**WELWYN HATFIELD BOROUGH COUNCIL  
EXECUTIVE DIRECTOR - PLANNING, PUBLIC PROTECTION AND GOVERNANCE**

**DELEGATED APPLICATION**

**Application No:** 6/2020/2878/HOUSE  
**Location:** 53 Clover Way Hatfield AL10 9FN  
**Proposal:** Erection of single storey rear extension and conversion of existing garage into habitable room  
**Officer:** Mr Sukhdeep Jhooti

**Recommendation:** Refused

PROPOSED GROUND FLOOR PLAN

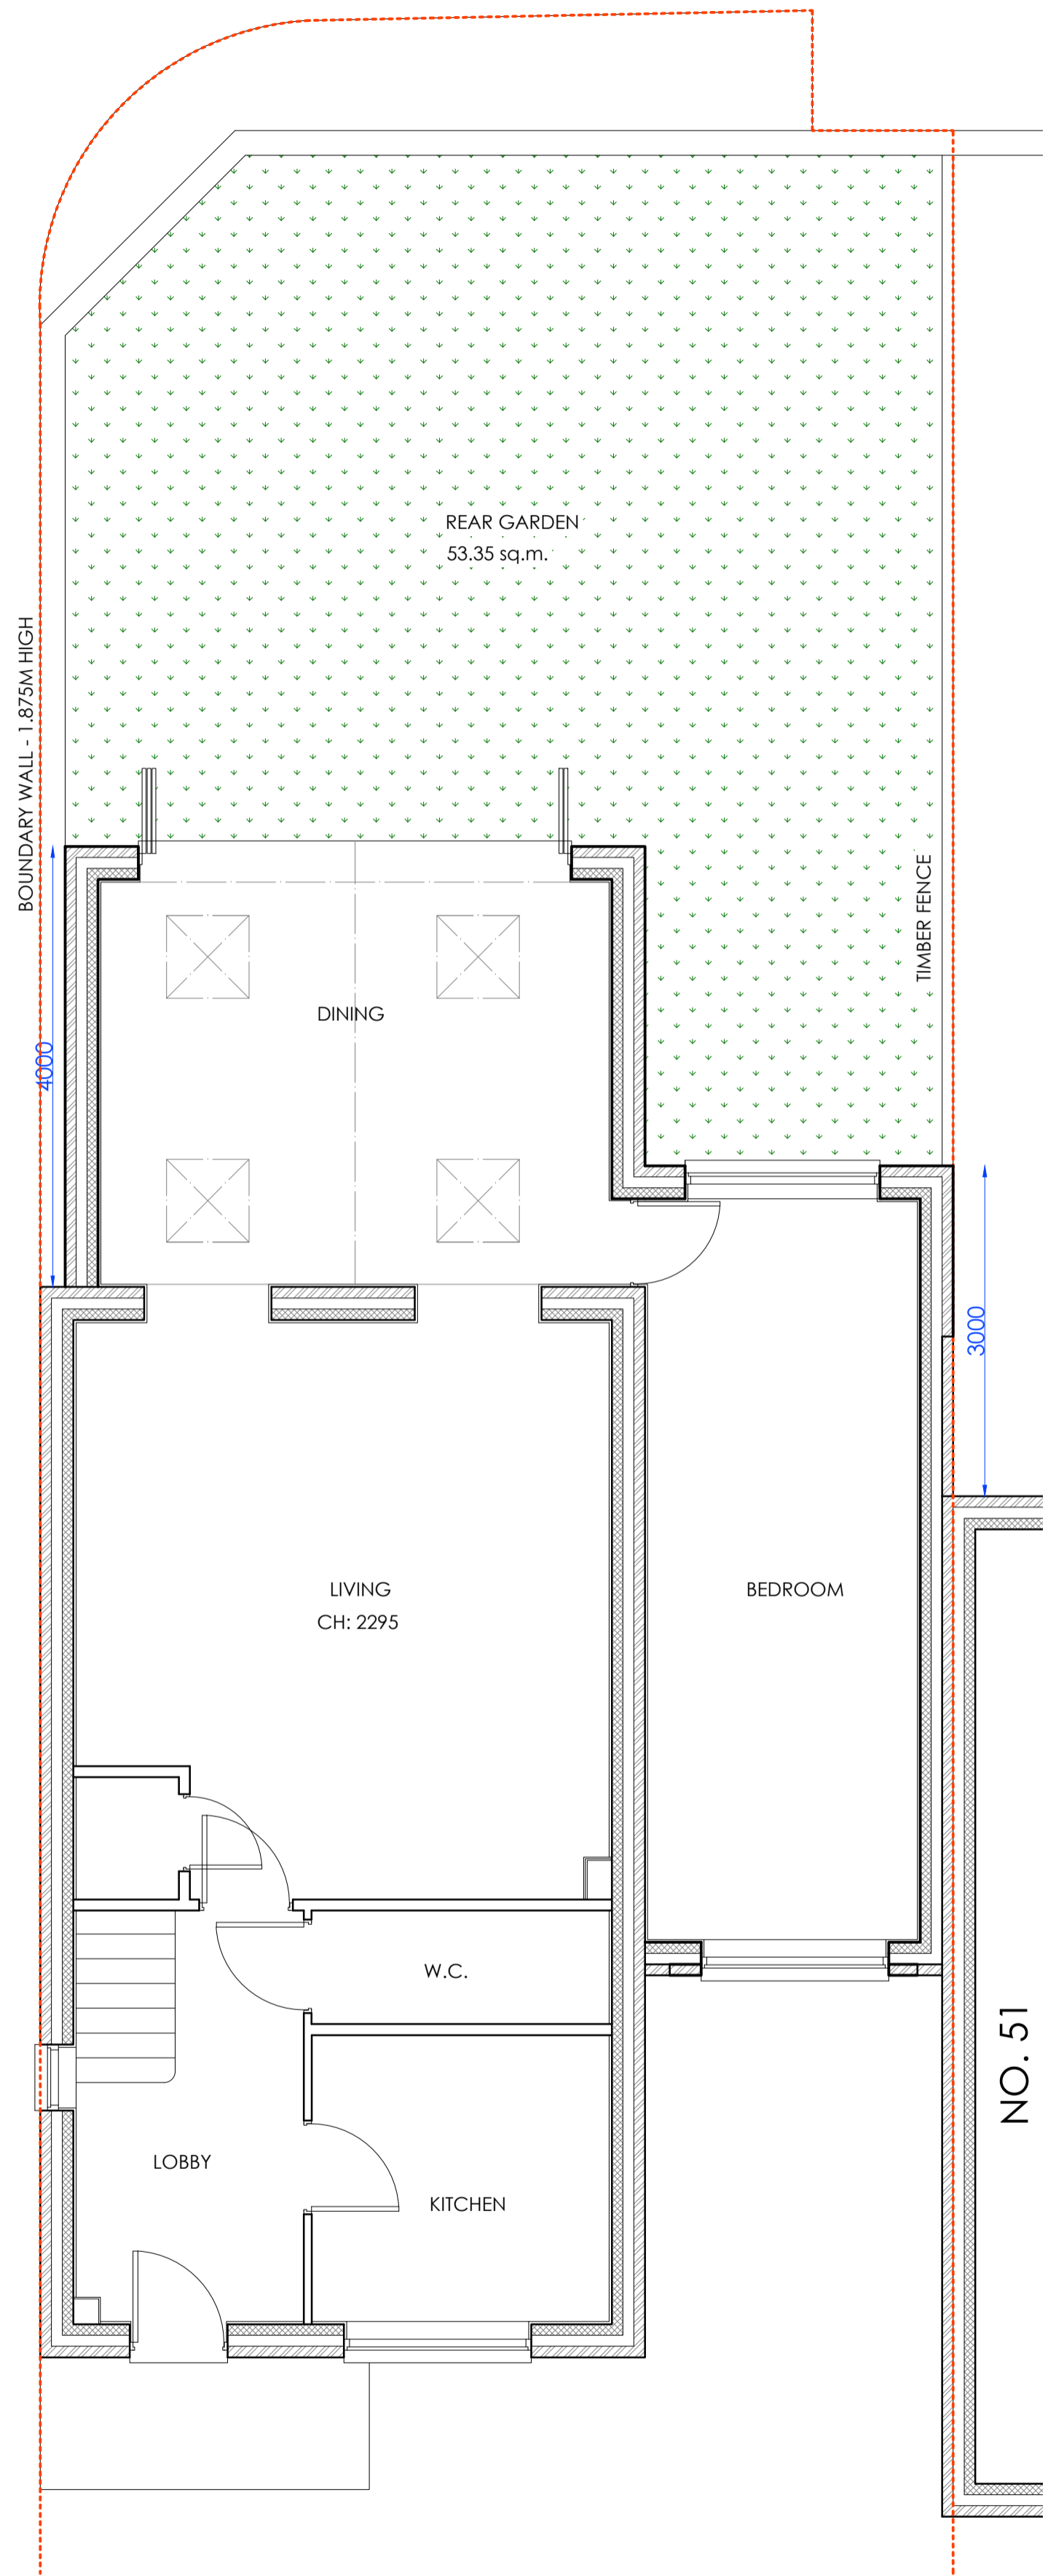
<b>Impact on neighbours</b>	<p>The proposed garage conversion into a habitable room with a window would not result in significant increases in the levels of overlooking compared with the existing situation. It is unlikely to result in greater intensification, noise nuisance and general activity compared with the existing situation to warrant refusal of planning refusal.</p> <p>The proposed single storey rear extension would be of an overall height, width and depth which would not result in a significant loss of light, outlook or privacy</p>

1. The proposal by reason of the deficit of on-site parking for the resultant dwelling, would increase the pressure for on-street parking which would not be compatible with the maintenance and enhancement of the character of the area and accordingly fail to provide a high standard of design. The proposal is therefore contrary to the National Planning Policy Framework; Policies D1, D2 and M14 of the Welwyn Hatfield District Plan 2005; the Supplementary Planning Guidance for Parking Standards 2004; and the Council's Interim Policy for Car Parking Standards.

PROPOSED REAR ELEVATION

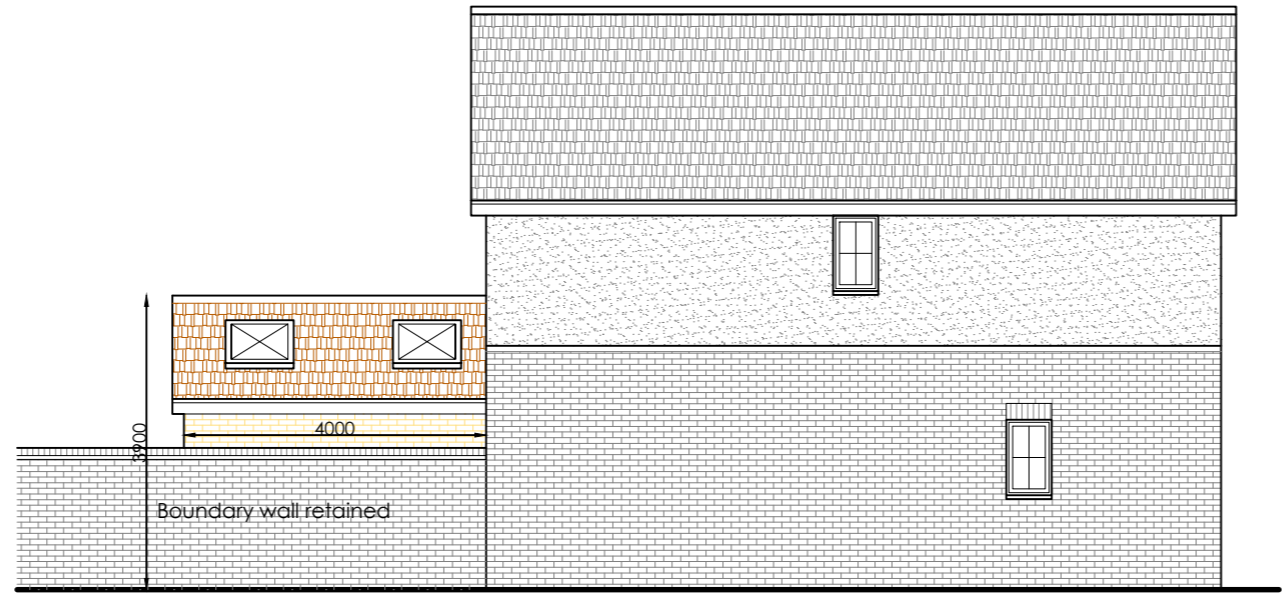
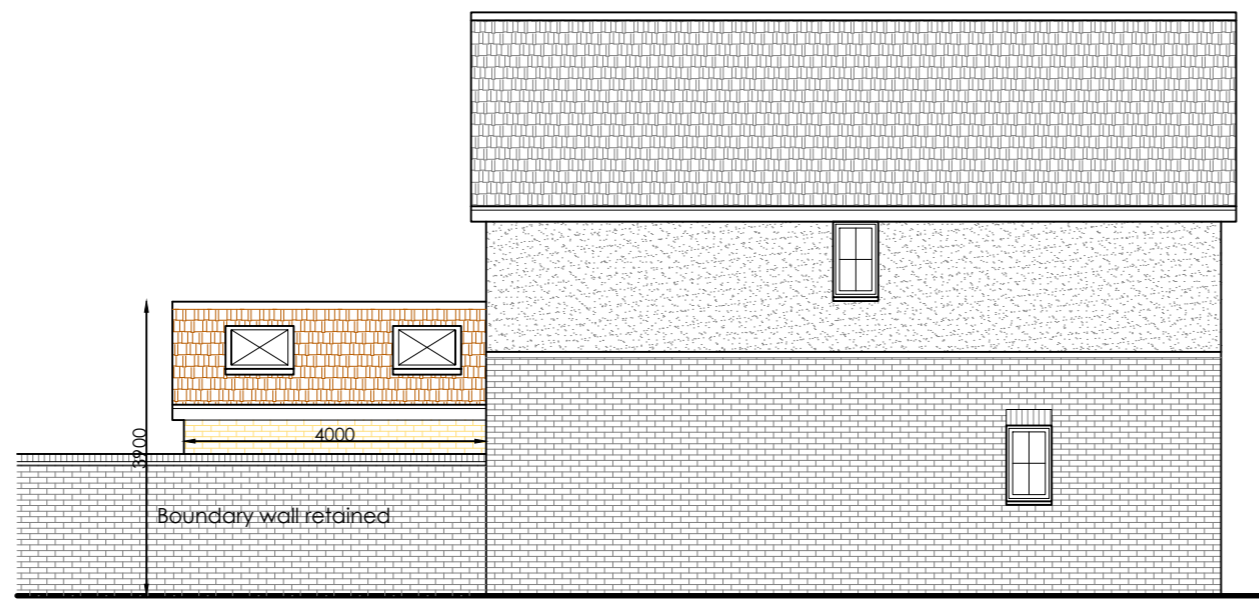
<b>Main Issues</b>			
<b>Design (form, size, scale, siting) and Character (appearance within the streetscene)</b>	<p>Policies D1 and D2 of the District Plan require the standard of design in all new development to be of a high quality and that all new development respects and relates to the character and context of the area in which it is proposed. These policies are expanded upon in the Council's SDG.</p> <p>The NPPF places a clear emphasis on high quality design and explains that planning permission should be refused for development of poor design that fails to take the opportunities available for improving the character and quality of an area and the way in functions, taking into account any local design standards or style guides in plans or supplementary planning documents.</p> <p>The proposed garage conversion into a habitable room would result in the removal of the existing garage door which would be replaced with a window. It would appear the window would match existing but no elevational detail has been provided. This could be secured by condition in the event of planning approval. The garage conversion into a habitable room with a window subject to the window matching the existing house would appear acceptable when viewed from the streetscene.</p> <p>The proposed single storey rear extension would be built from complementary materials and would appear proportionate to the size of the application dwelling and rear garden area. The proposed rooflights would not over-dominate the roofslope of the proposed single storey rear addition in terms of profile, design and number.</p>

<p>when viewed from the rear garden area and habitable room glazing of number 51 Clover Way. The proposed rooflights would not cause direct overlooking of this neighbours garden area or habitable room glazing. No other neighbouring dwellings would be affected due to its size, siting and scale.</p>
<p><b>Access, car parking and highway considerations</b></p>	<p>Paragraph 105 of the NPPF states that if setting local parking standards authorities should take into account the accessibility of the development, the type, mix and use of the development, availability of public transport; local car ownership levels and the overall need to reduce the use of high emission vehicles. District Plan Policy M14 and the Parking Standards SPG use maximum standards and are not consistent with the NPPF and are therefore afforded less weight. In August 2014 the Cabinet Housing and Planning Panel approved the Interim Policy for Car Parking Standards and Garage Sizes document. This document identifies the car parking standards set out in the SPG Parking Standards as guidelines rather than maximums and states that parking provision will be assessed on a case by case basis.</p> <p>The Council's Car Parking Standards SPG identifies the application site as being within Zone 4 (Zone 1 being the most accessible) where residential dwellings with 3 or more bedrooms typically require 2.25 car parking spaces.</p> <p>Under the proposals, the number of bedrooms at the dwellinghouse would rise from three to four. With this in mind, the SPG identifies that dwellings with 4 or more bedrooms typically require 3 car parking spaces. The existing garage is being lost to parking and only one car parking space is retained within the site frontage resulting in a deficit of 2 car parking spaces. Although it is accepted that the site is accessible from some facilities, it does not form one of the most accessible parts of the Borough and is not comparable to the town centres. The application site is located outside of a convenient walking distance from the nearest train station.</p> <p>Whilst the applicant has indicated only one space is in use, personal circumstances and occupants change over time. Weight is given to the potential of a 4 bedroom dwelling requiring 3 car parking spaces.</p> <p>It is considered that the potential for a displaced vehicle being parked on-street would be harmful to the character and appearance of the area and the surrounding residential development. In making this assessment consideration has been given to the availability of on-street parking and the density of the surrounding development. The site has an inadequate ability to provide on-site car parking. Moreover, the imposition of a planning condition requiring an additional space would be unreasonable and would not meet the test specified in the NPPF 2019.</p> <p>The immediate streetscene of Clover Way is characterised by houses with on-site parking in the form of driveways and garages. Case Officer observation has revealed that there is parking pressure along the street at the time of the site visit. There is little opportunity for on-street parking as much of the area sees driveways, garages, narrowing of roads and a tight highway geometry, and these features limit the ability to conveniently or safely park on the highway, as well as some parking hampering the safe use of footways. Additional parking on the road is likely to add to parking pressures within the vicinity, and this would be harmful to the convenience and safety of other road users and to pedestrians.</p> <p>Furthermore, if planning permission were to be granted it would be difficult to resist similar applications from numerous other properties within the wider estate where a similar arrangement exists. Although each proposal must be considered on its own merits, consistency in decision making is a material</p>
